## Appeal Decision

### Appeal Ref: 6003832

#### 1 Lockgate Rise, Birkenshaw BD11 2PL

- The appeal is made under section 78 of the Town and Country Planning Act 1990 (as amended) against a refusal to grant approval required under Article 3(1) and Schedule 2, Part 1, Class A of the Town and Country Planning (General Permitted Development) (England) Order 2015 (as amended) (the GPDO).
  - The appeal is made by Rebecca Johnson against the decision of Kirklees Metropolitan Council.
  - The application Ref is 2025/93213.
  - The development proposed is a single storey living room extension.
-

Drawing Title  
**PROPOSED**

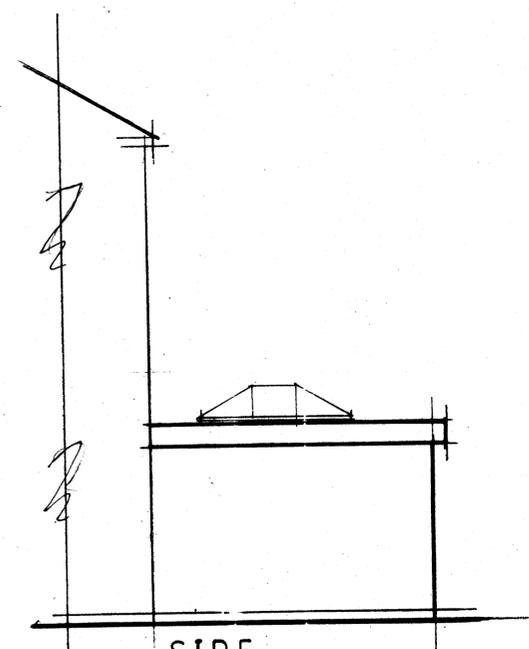
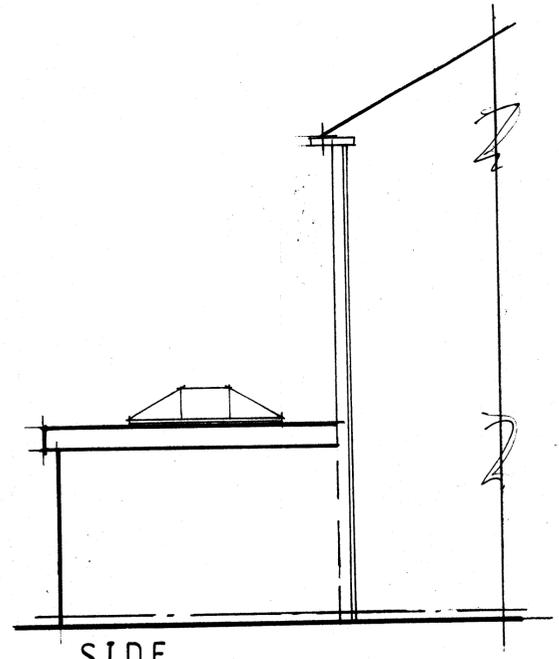
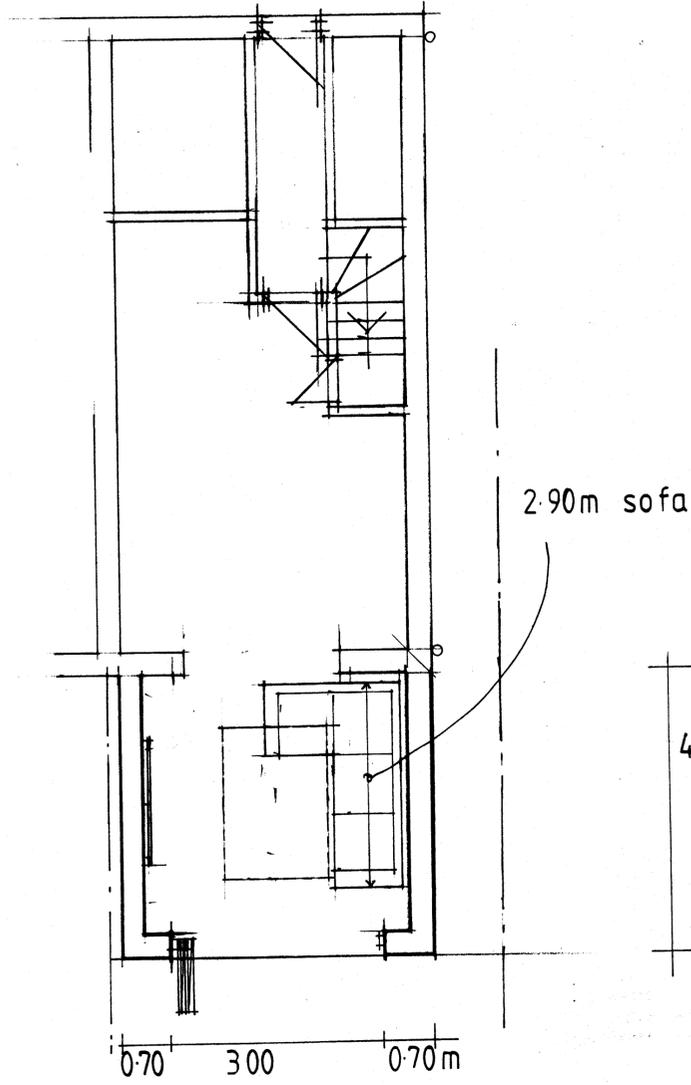
8. The existing projection comprises three elevations. The rear elevation contains patio doors opening onto the garden, with its flanking elevations featuring windows which are set perpendicular to the rear wall. Despite its predominately glazed construction, the projection occupies a substantial proportion of the ground floor rear elevation of the property. Moreover, and as observed on my site visit, its height together with the depths of its flank elevations is not insignificant as it provides for internal floorspace.

9. As a result, I find that the existing rear projection is more than just an architectural detail or decorative feature and its flank elevations constitute walls forming side elevations of the dwellinghouse for the purposes of paragraph A.1(j). As the proposed development would extend beyond these side walls and would exceed half the width of the original dwellinghouse, it would fail to comply with paragraph A.1 (j) (iii) and so would not be granted planning permission by Article 3, Schedule 2, Part 1, Class A of the GPDO.
